Review Response

Project Name: Seda Bulkhead

Response To: SHL23-015 and SEP23-004 SUB4

# HARDSCAPE CALCULATION DRAWING - EXISTING

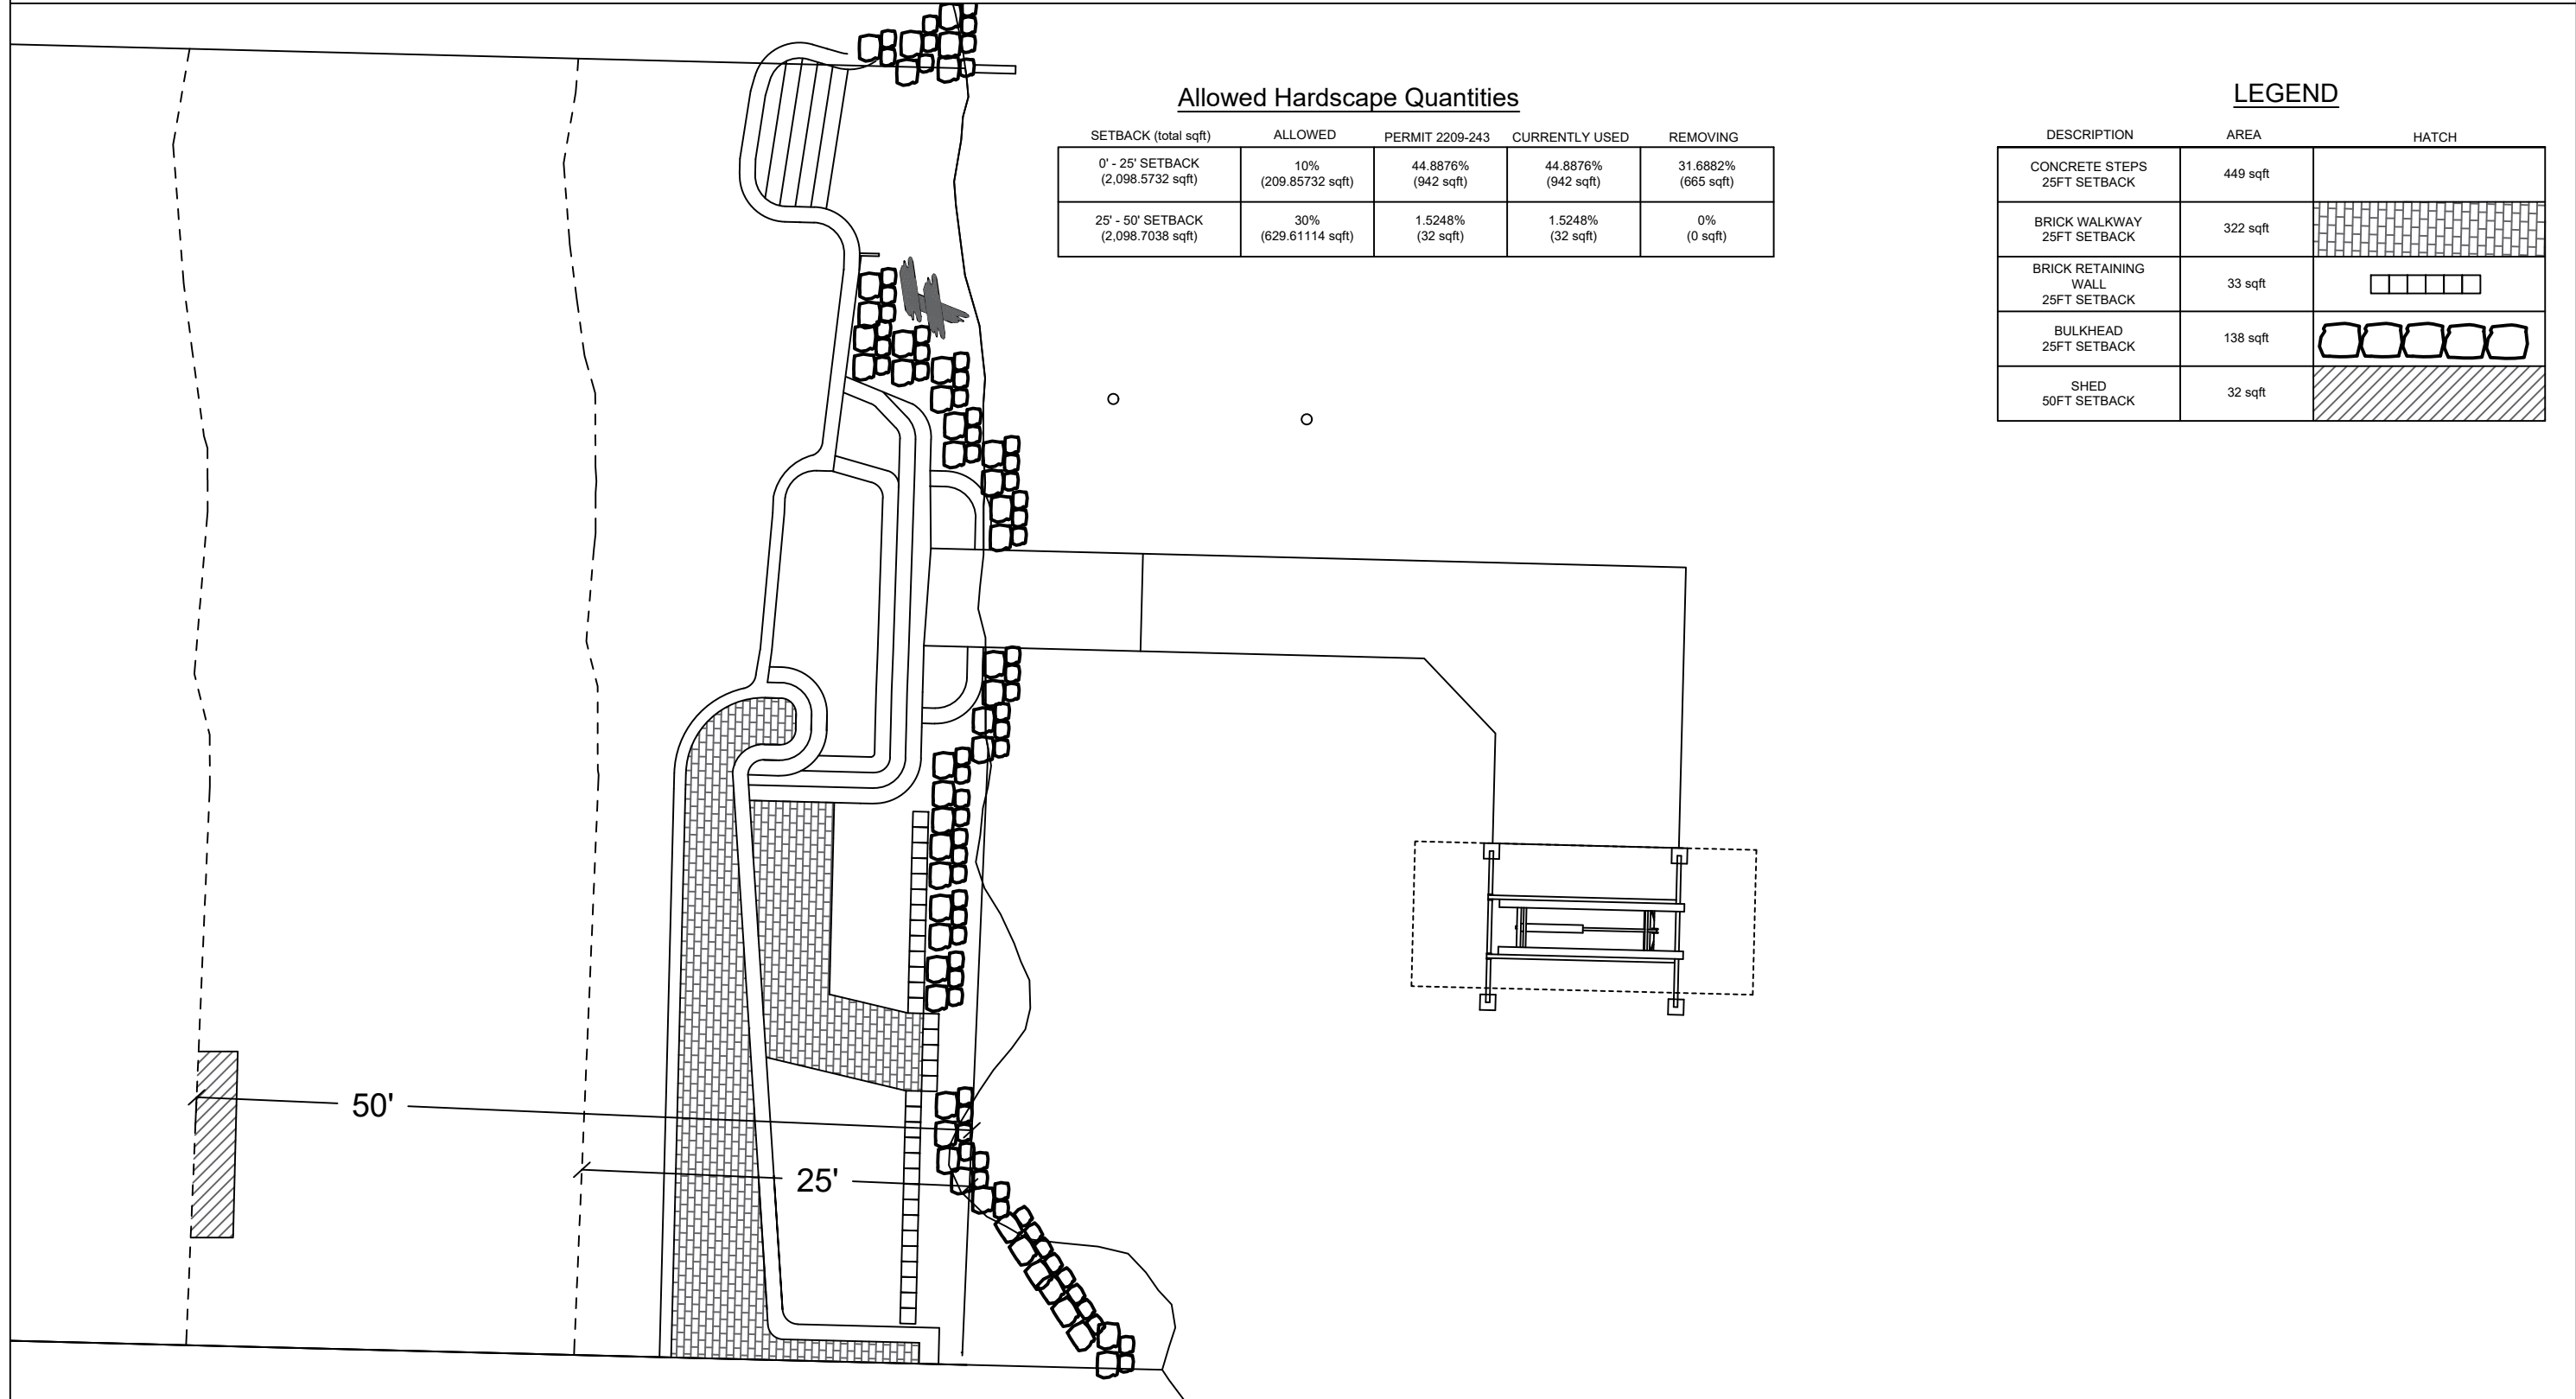
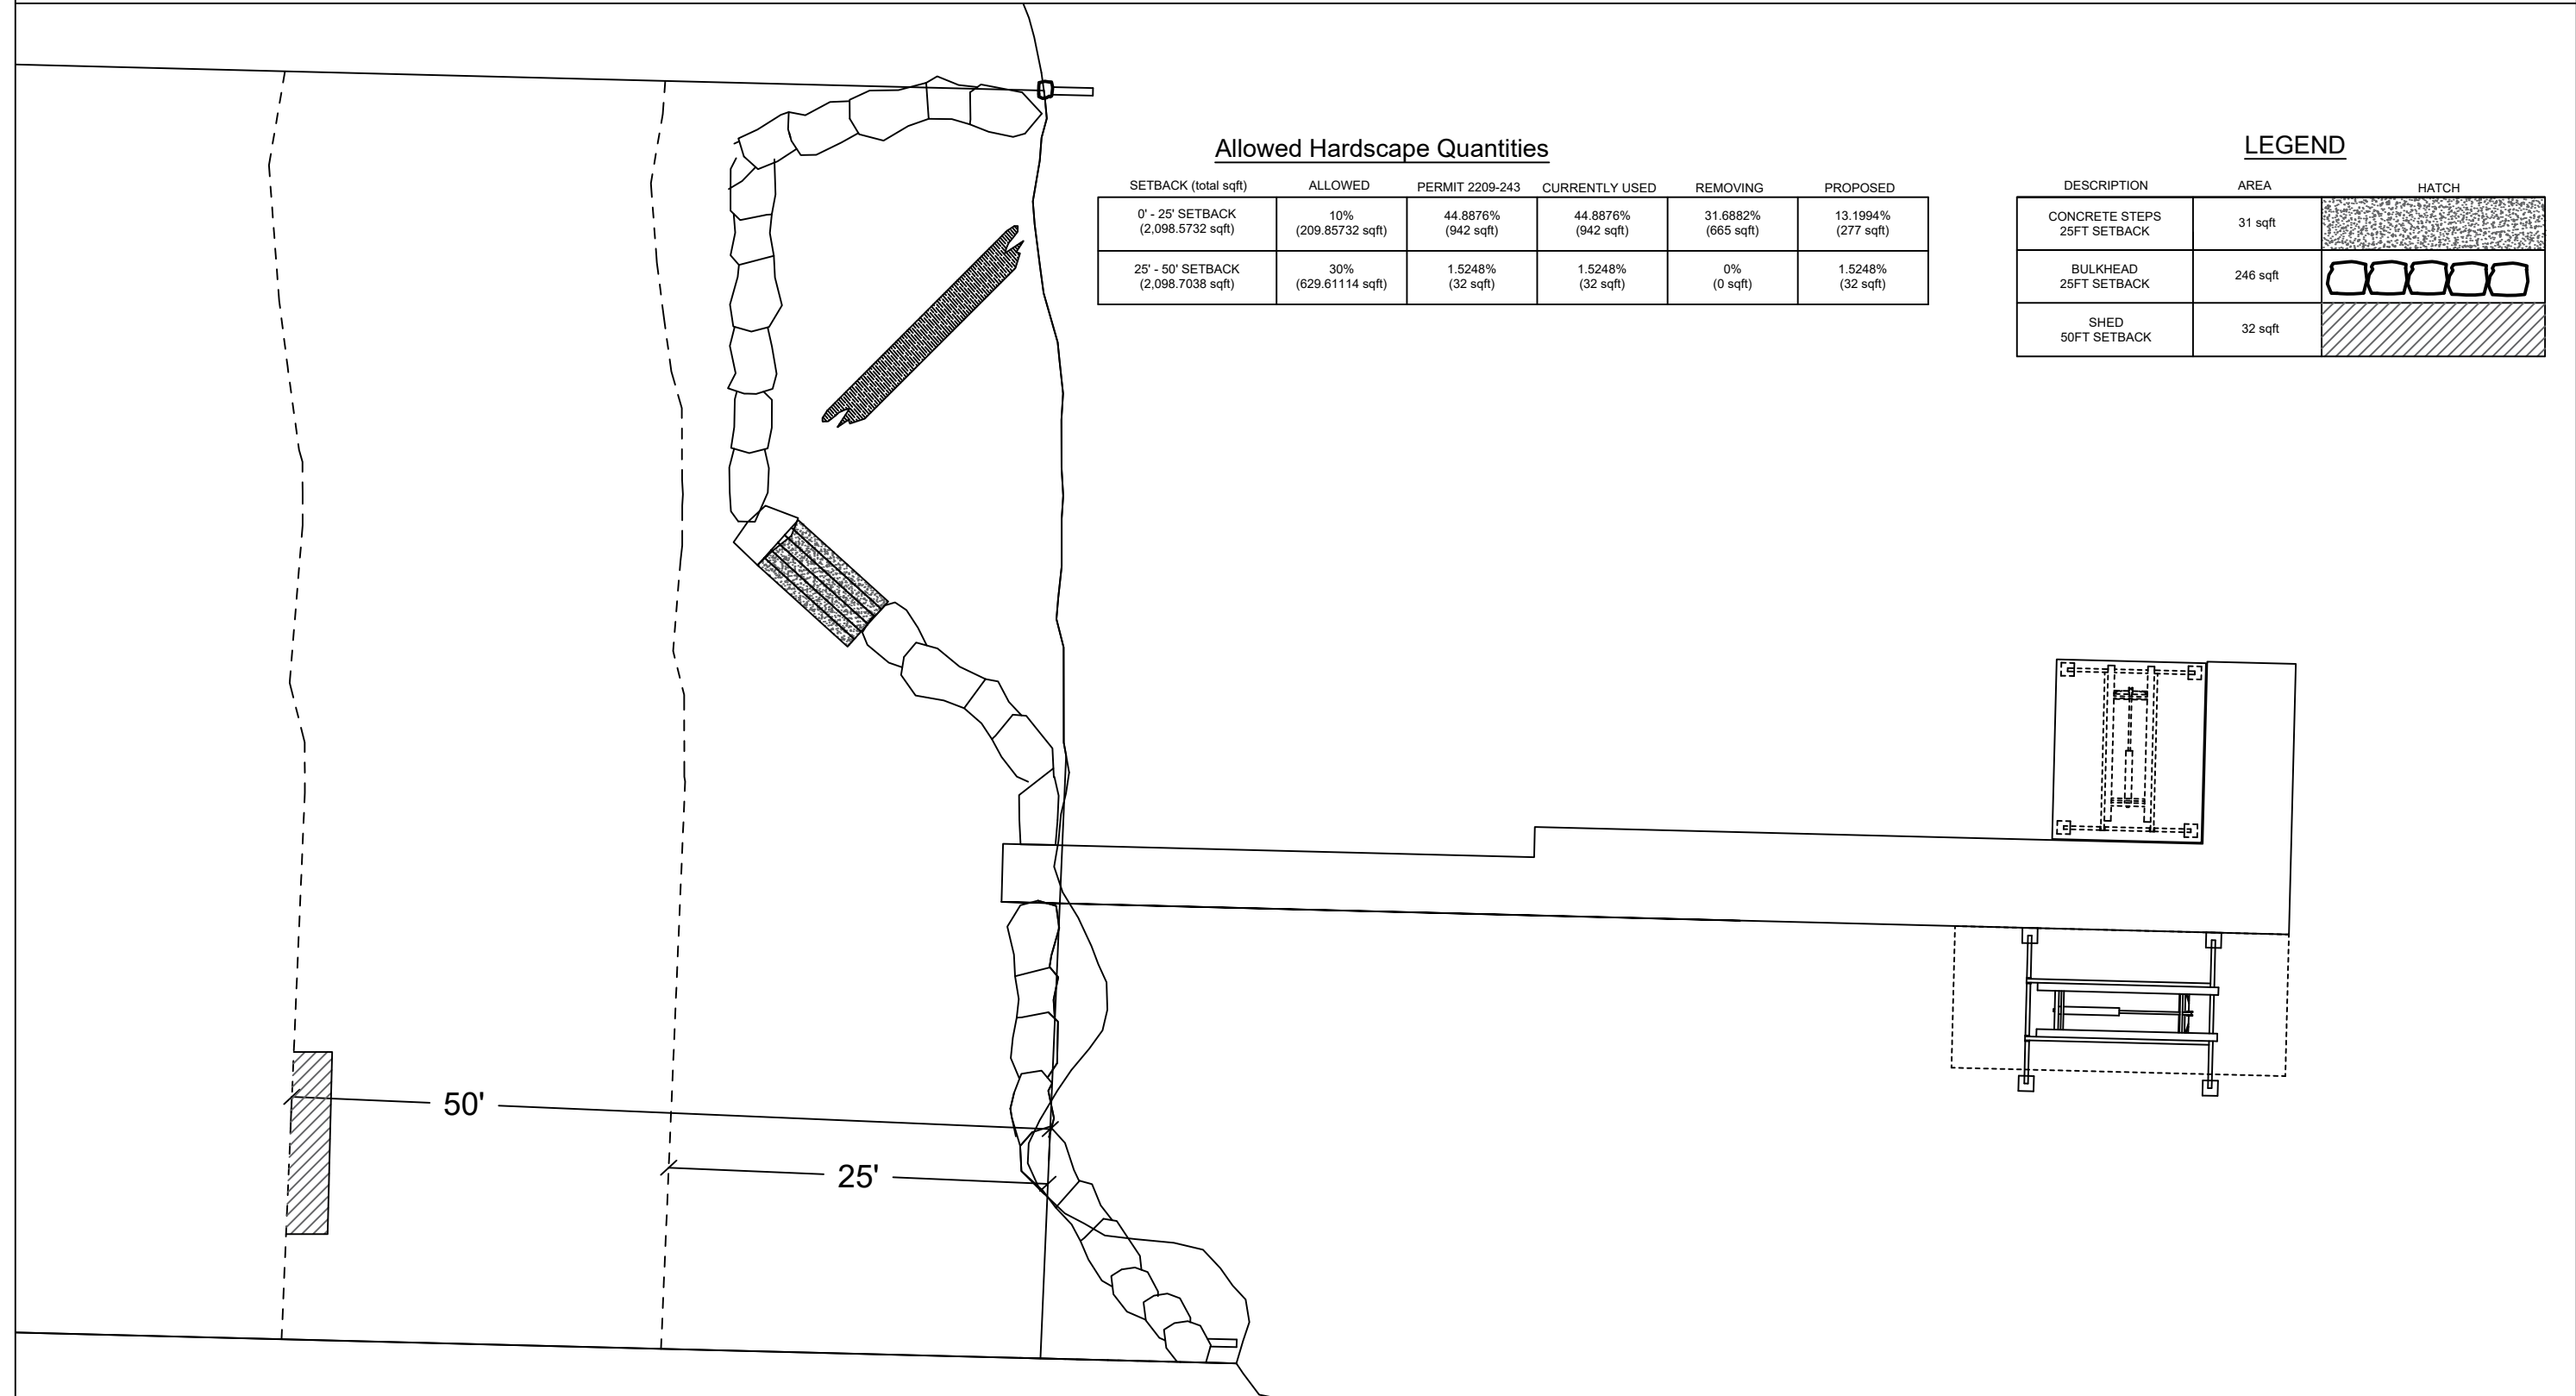
All existing and proposed hardscape calculations noted on Sheets 14.0 and 15.0 are in conformance with MICC per code references above.

1. Per MIMC 19.02.060 – Lot Coverage – Regulated Improvements (C)(5) -Rockerries/retaining walls. Rockerries and retaining walls shall be exempt from the maximum impervious surface limits.

Existing 942 sqft of impervious surface is permitted under 2209-243, the proposed 277 sqft is comprised of repair, replacement, and reconfiguration of the existing permitted impervious area.
